From:
Sent: 20 May 2020 09:48
To: Planning <Planning@Cherwell-DC.gov.uk>
Subject: 3rd Party Planning Application - 19/01740/HYBRID - APR 20

Our DTS Ref: 60042
Your Ref: 19/01740/HYBRID - APR 20

Re: LAND ADJ TO PROMISED LAND FARM, WENDLEBURY ROAD, CHESERTON, OXFORDSHIRE , OX25 2PA

Concept FW Drainage Layout 1:2500

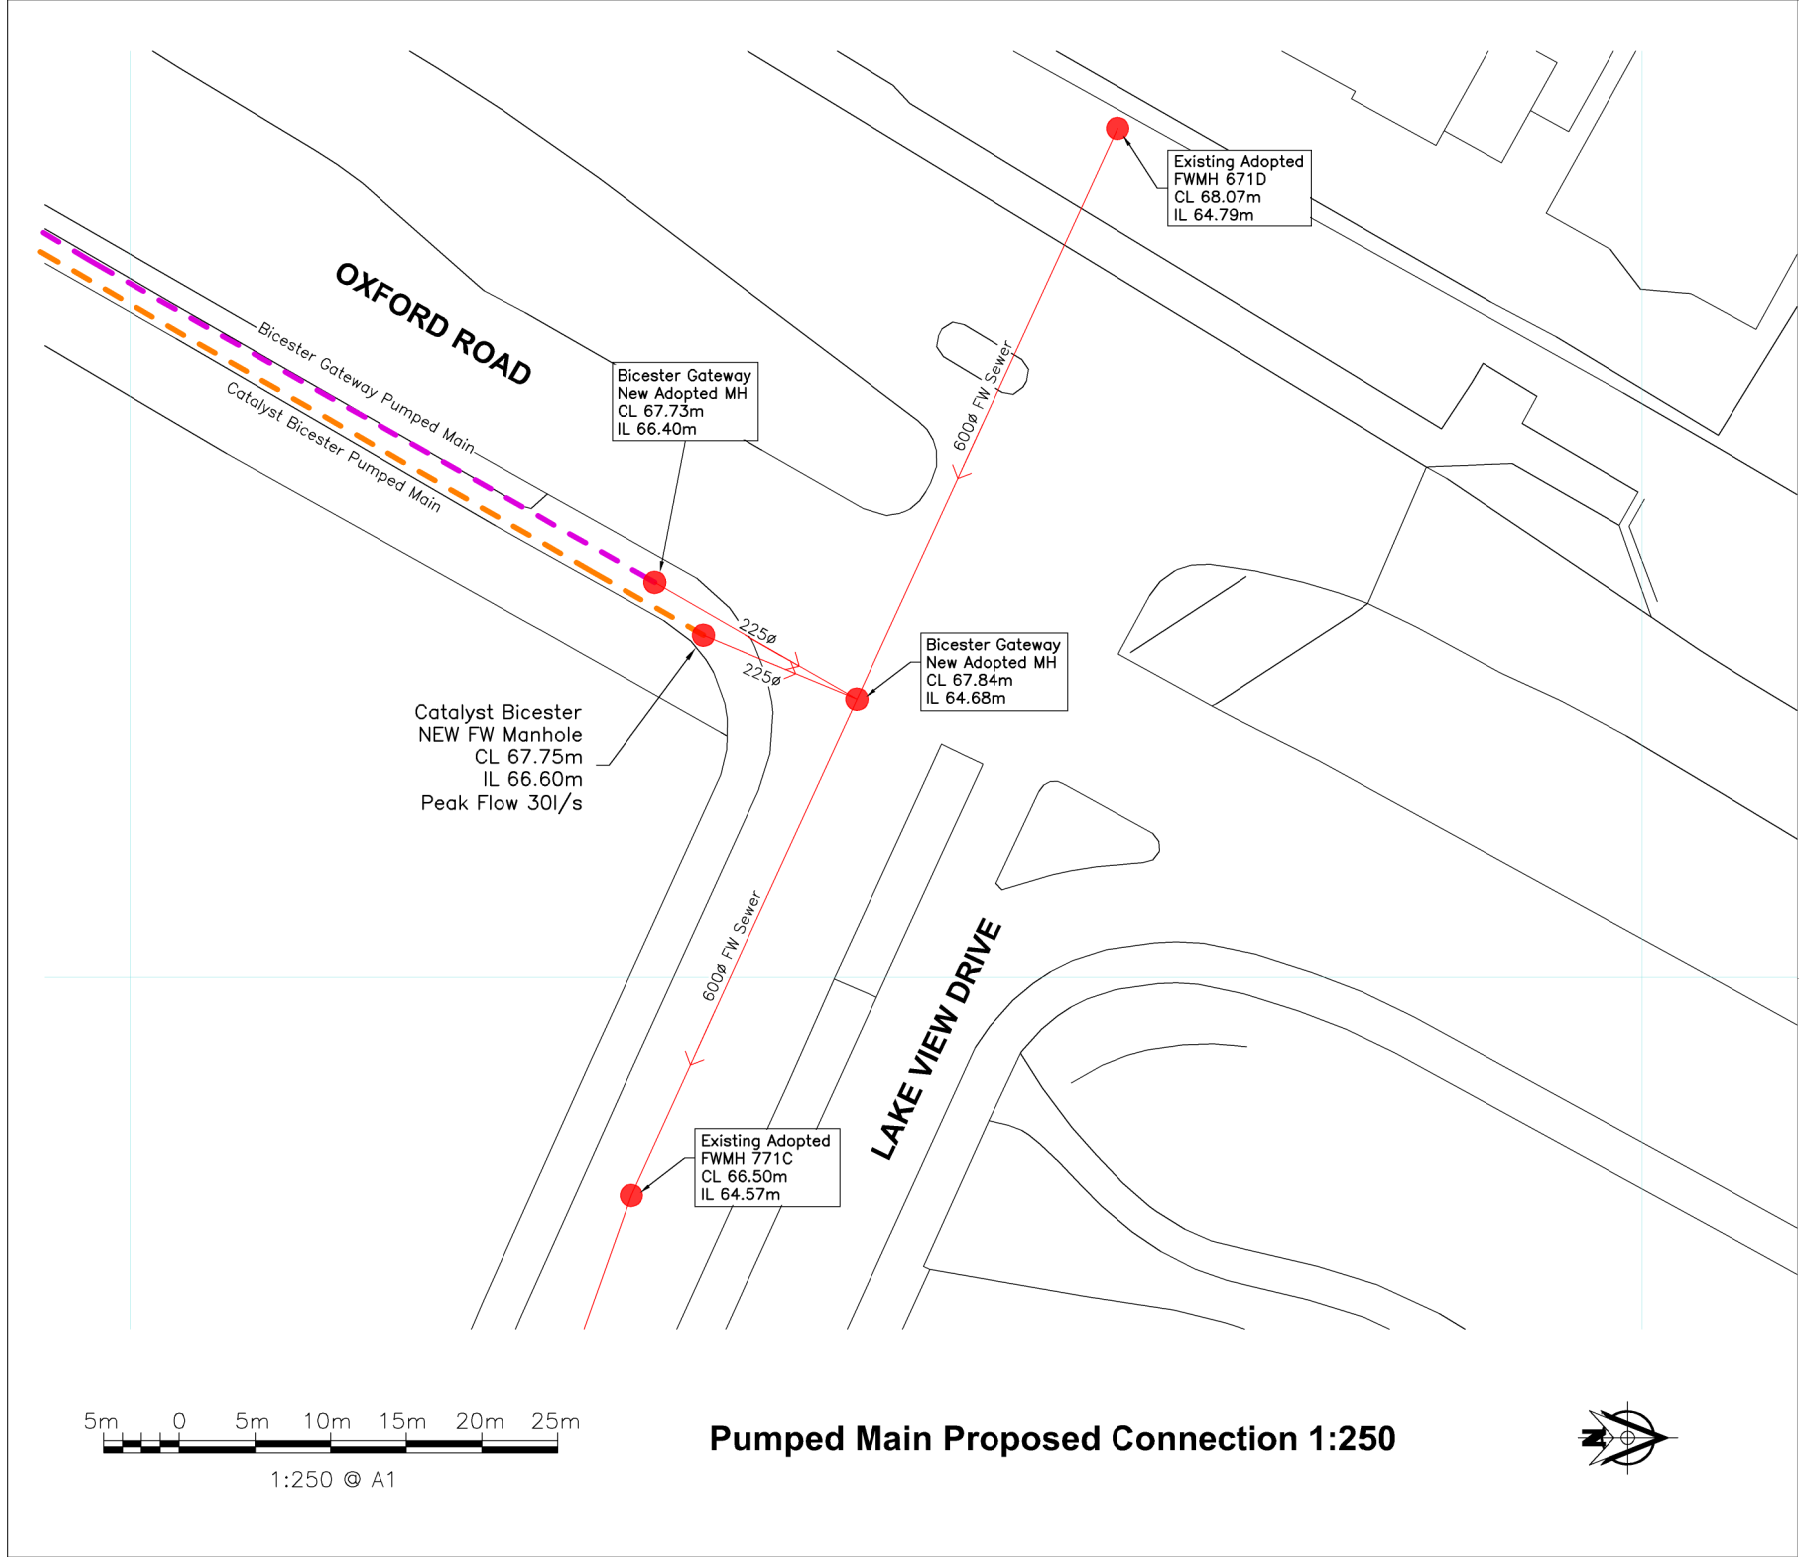
With the information provided, Thames Water has been unable to determine the waste water infrastructure needs of this application. Thames Water has contacted the developer in an attempt to obtain this information and agree a position for FOUL WATER drainage, but have been unable to do so in the time available and as such, Thames Water request that the following condition be added to any planning permission. "No properties shall be occupied until confirmation has been provided that either:- 1. Capacity exists off site to serve the development, or 2. A housing and infrastructure phasing plan has been agreed with Thames Water. Where a housing and infrastructure phasing plan is agreed, no occupation shall take place other than in accordance with the agreed housing and infrastructure phasing plan, or 3. All wastewater network upgrades required to accommodate the additional flows from the development have been completed. Reason - Network reinforcement works may be required to accommodate the proposed development. Any reinforcement works identified will be necessary in order to avoid sewage flooding and/or potential pollution incidents. The developer can request information to support the discharge of this condition by visiting the Thames Water website at thameswater.co.uk/preplanning. Should the Local Planning Authority consider the above recommendation inappropriate or are unable to include it in the decision notice, it is important that the Local Planning Authority liaises with Thames Water Development Planning Department (telephone 0203 577 9998) prior to the planning application approval.

Thames Water advise that a drainage strategy should be provided with the details of the points of connection to the public sewerage system as well as the anticipated size of the proposed sewer connection/s (including flow calculation method and whether the flow will be discharged by gravity or pumped) into the proposed connection points. If the drainage strategy is not acceptable an impact study will need to be undertaken.
